Planning Application - Anglian Water Response

Anglian Water site reference:	PLN-0244169
Response date:	20 July 2026
Local Planning Authority:	South Holland
Planning application reference:	H16-0552-26
Site address:	Land off Shakespeare Way Holland Park Spalding PE11 1GU
Proposal description:	Erection of a 3-storey care home development with associated car parking, amenity space and ancillary structures

Response prepared by Anglian Water Growth, Planning and Capacity Team.

102378-DCE-XX-XX-DR-C-5000

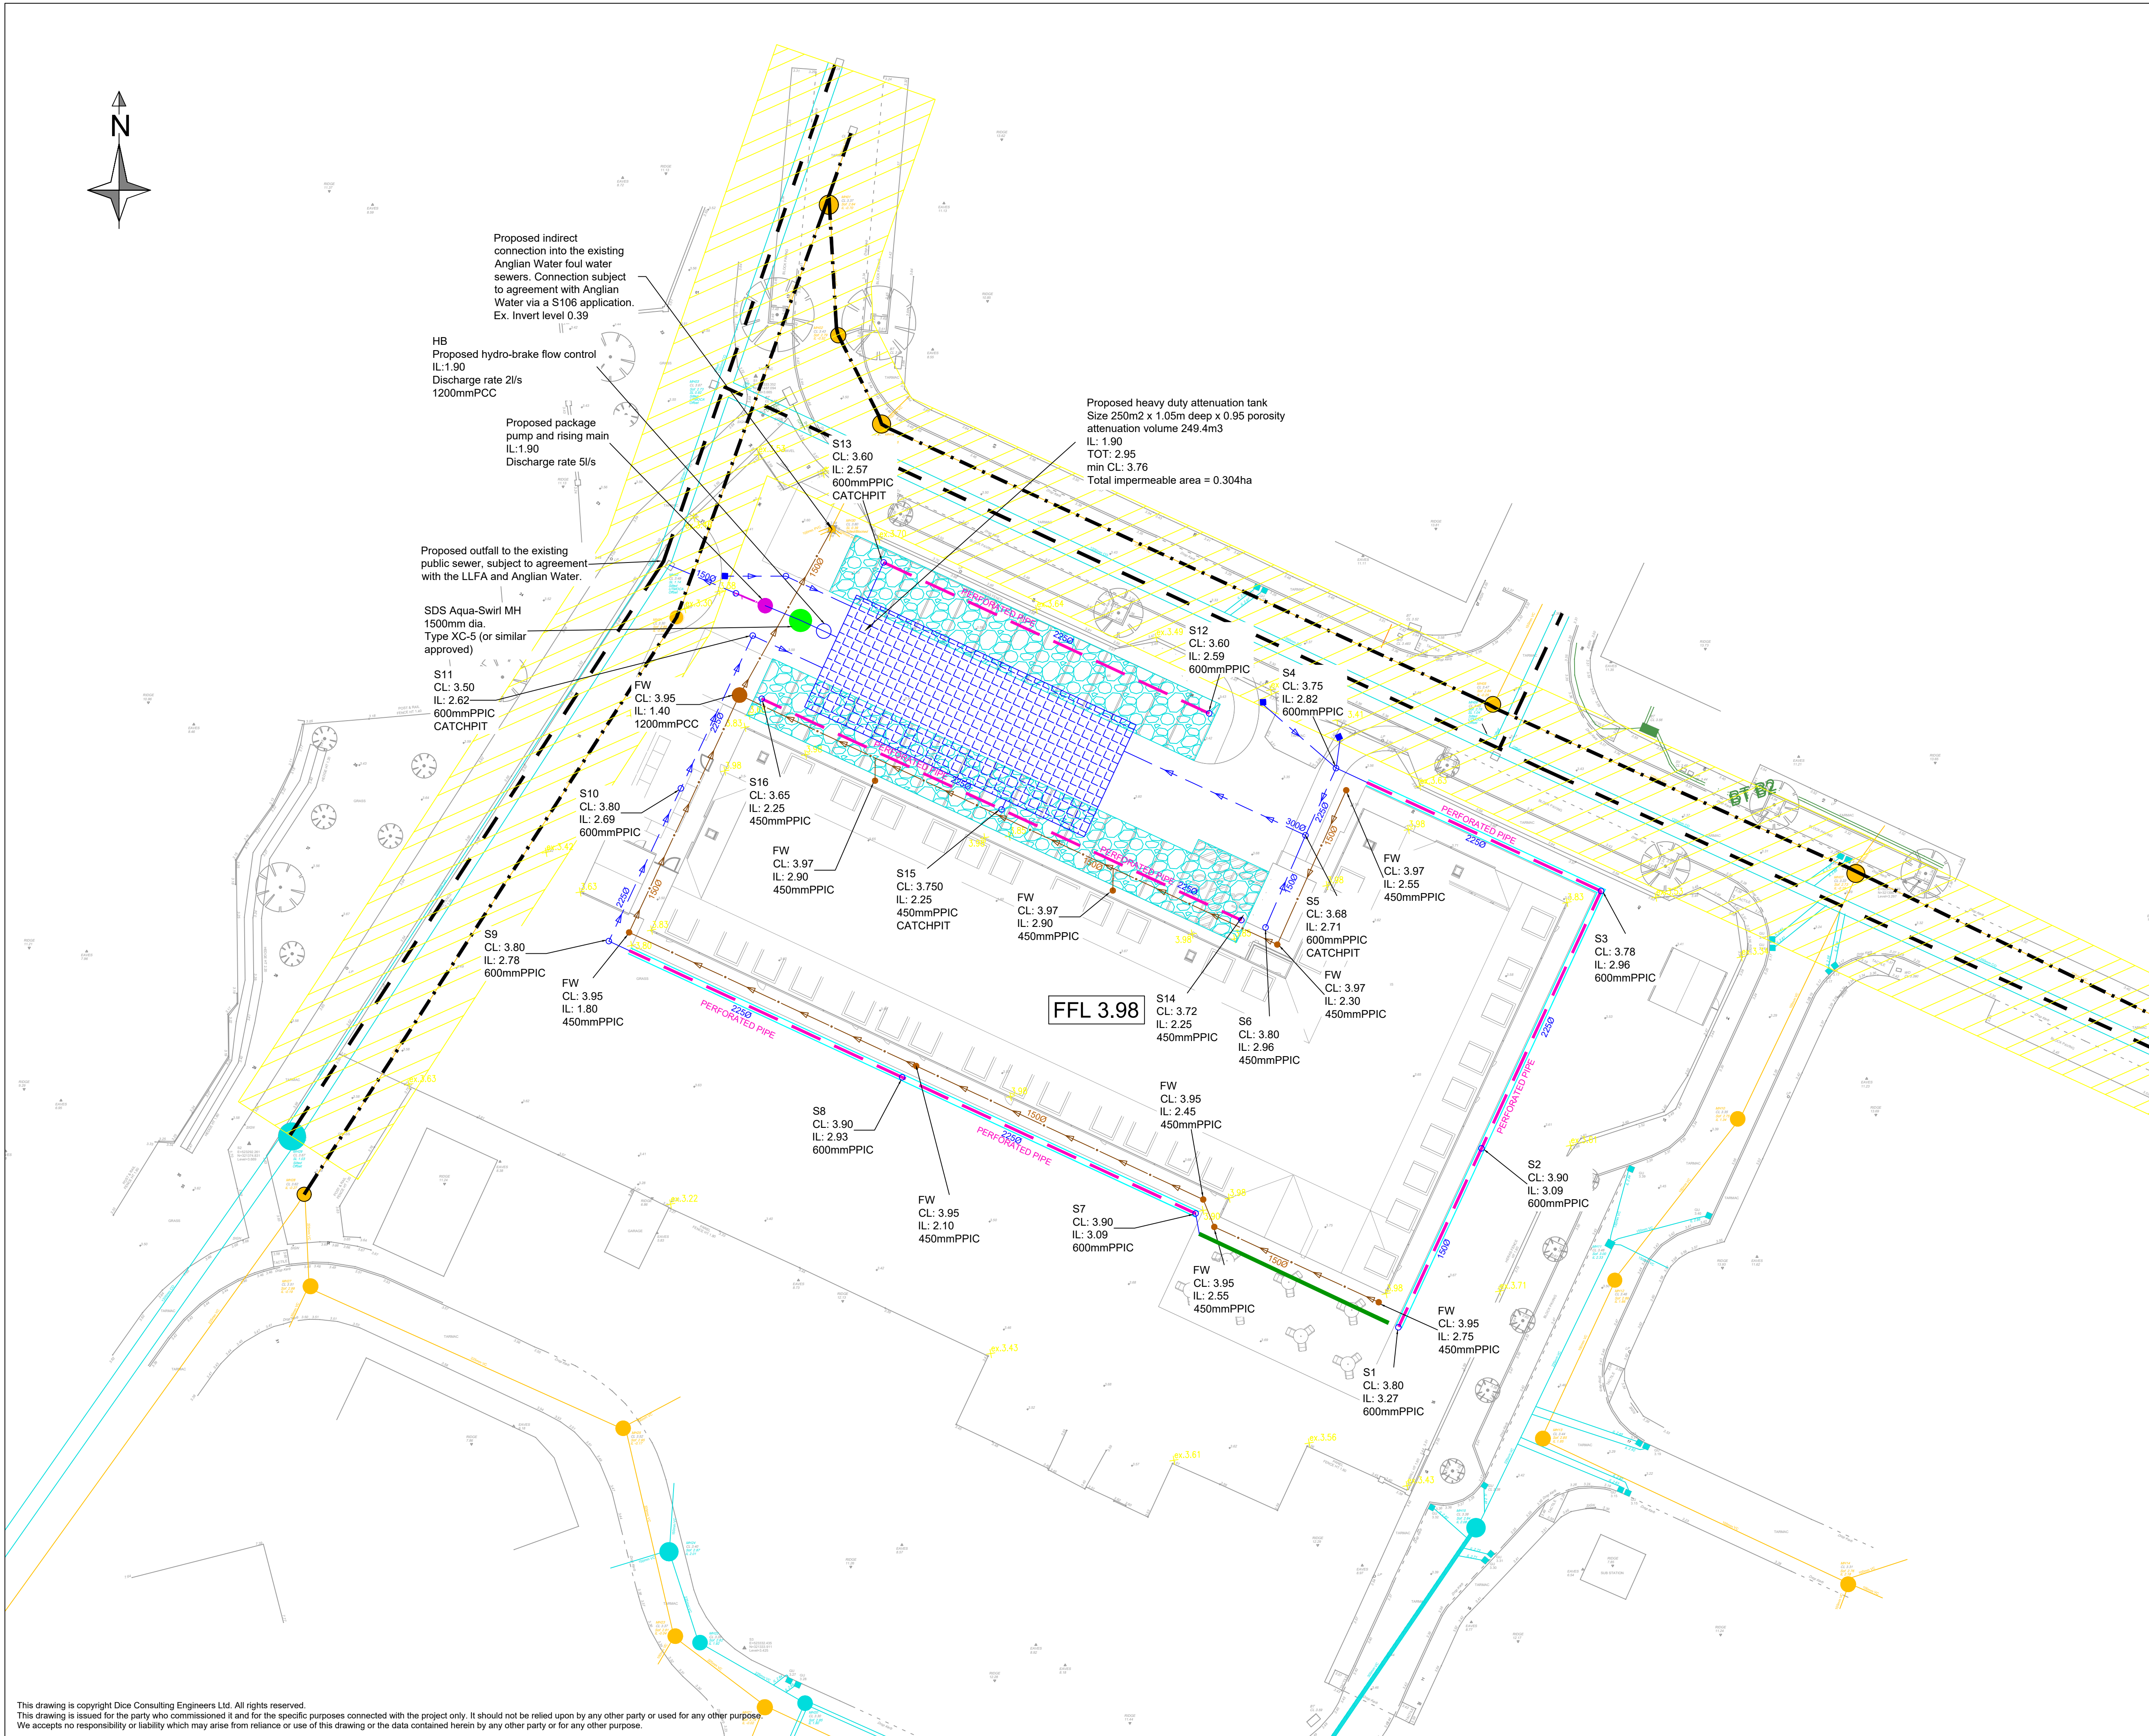
Anglian Water object to this application due to a lack of evidence confirming that the surface water hierarchy has been fully explored and a discharge rate that does not align with Anglian Water policy.

The Flood Risk Assessment DATE: May 2026 102378-DCE-XX-XX-RP-C-0002 Issue 1 states 'A package surface water pumping station is proposed downstream from the flow control. This will pump the surface water flows into the public sewers at 5l/s, which is the minimum discharge rate to be used with surface water pumping stations to minimise the risk of blockages and pump failure. Due to the presence of a flow control prior to the pump, the discharge rate from site will not exceed 2l/s'.

As the flow control is prior to the pumping station this statement is not clear. If the pumped rate is 5l/s then this would not be in accordance with Anglian Water's policy for the 1 in 1 year greenfield rate and minimum adoptable standard of 2l/s. 2l/s would be the maximum permitted to the public surface water sewer, and only once full hierarchy evidence has been presented.

If the applicant believes the surface water hierarchy has been fully explored, they will need to provide evidence that all other options have been exhausted and discounted in line with the Surface Water Hierarchy in order to overcome our objection including infiltration testing in accordance with BRE Digest 365.
